Your ref
BN/85/19/DOC

Our ref
PLAN-030542

Proposal: Approval of details reserved by condition imposed under ref BN/32/15/OUT relating to Condition Nos 6 - proposed surface water drainage, 7 - discharge of any flows to watercourses, 8 - SUDs system, 9 - future access & maintenance of any watercourse or culvert, 10 - surface water drainage, 11 - rising main & foul sewer and 15 - foul drainage system.

Site: BN/85/19/DOC: -Land Rear of Lillies, Yapton Road, Barnham, PO22 0AY.

APPENDIX D

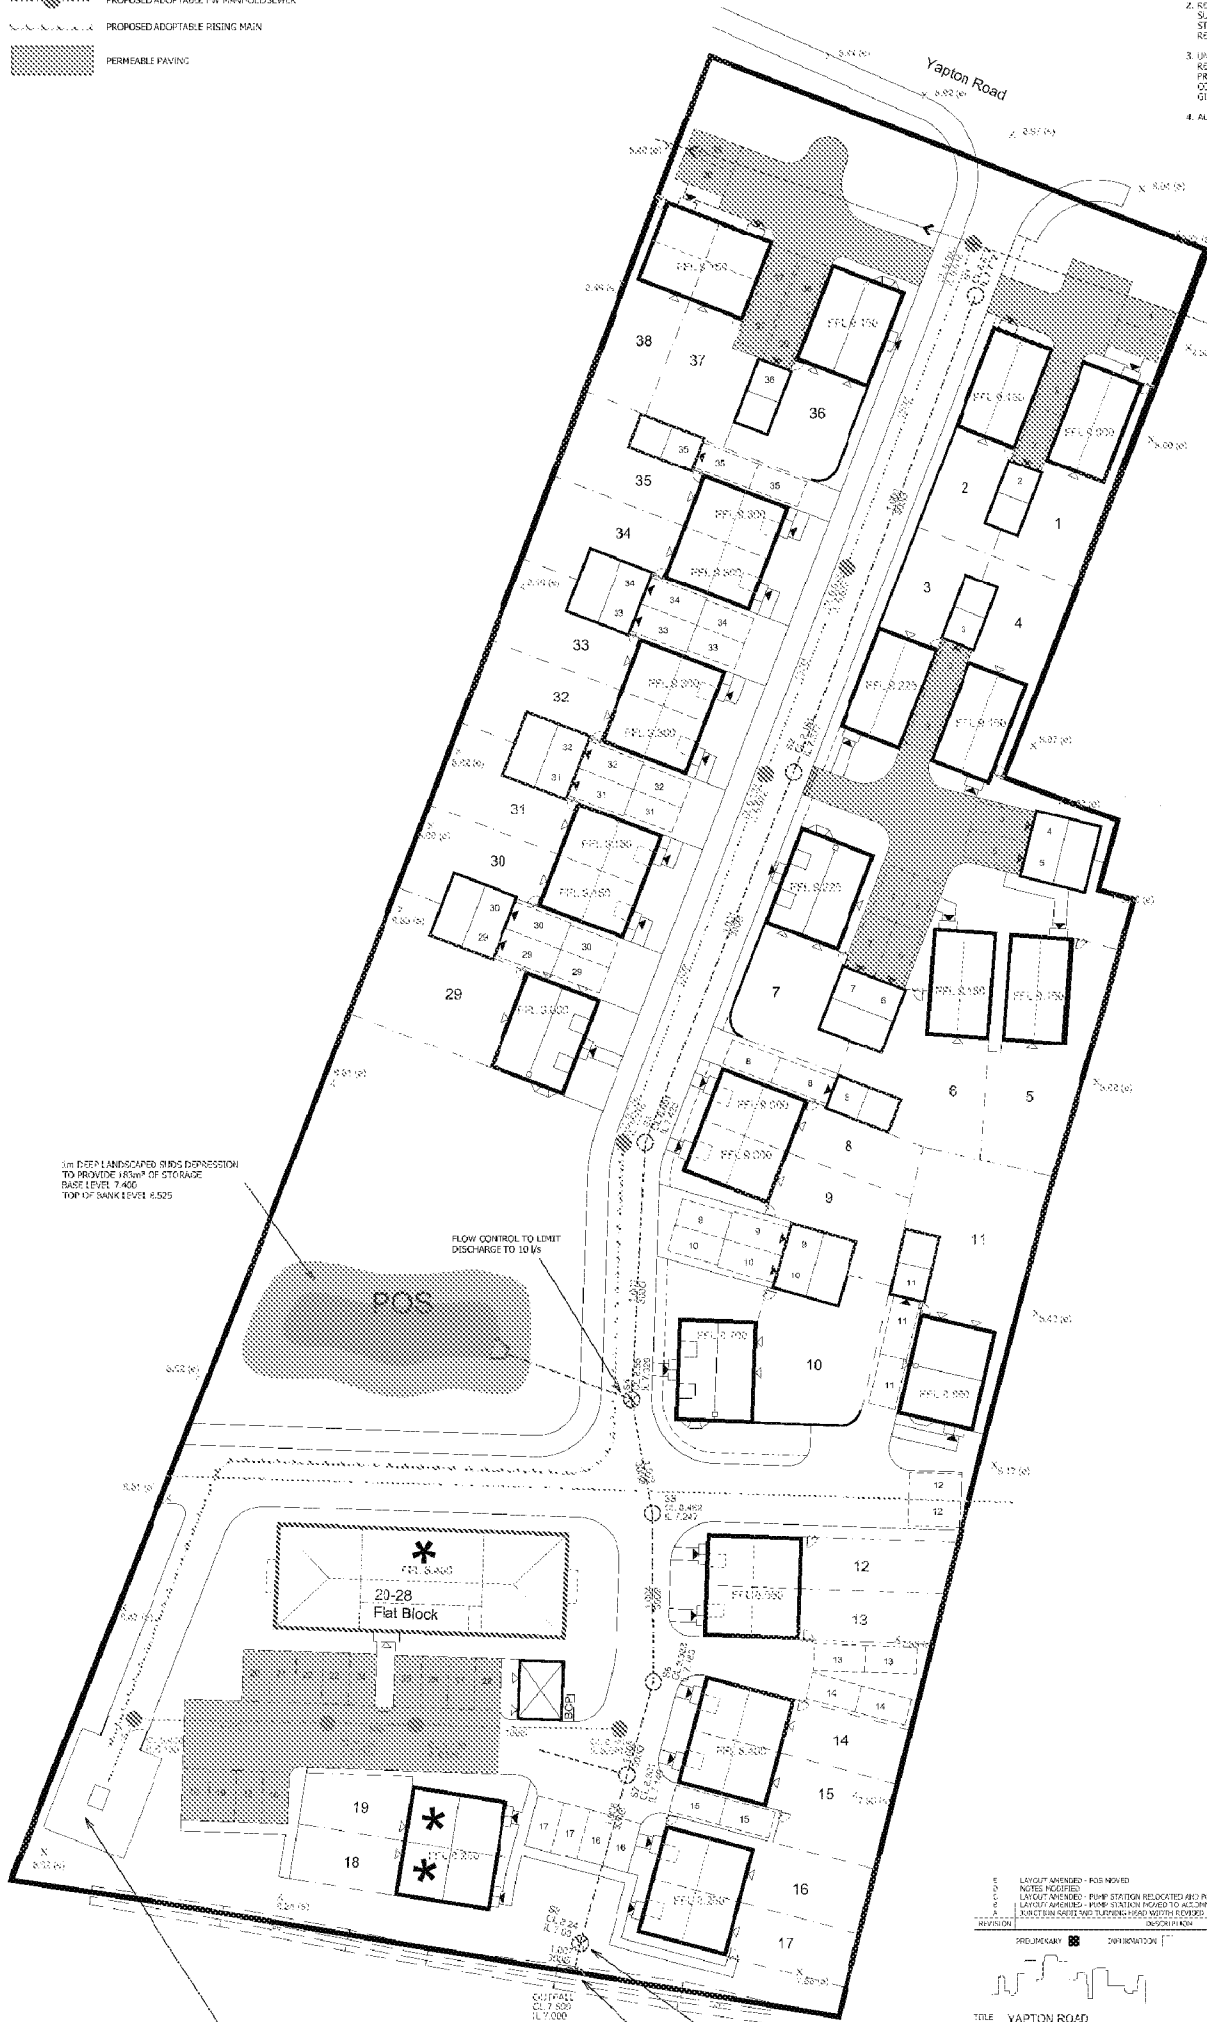
Southern Water cannot recommend discharge of condition 06, 08 and 10 relating to surface water drainage. The submitted drainage plan indicates proposed pumping station close to attenuation basin.

No soakaways, swales, ponds, watercourses or any other surface water retaining or conveying features should be located within 5 metres of a pumping station.
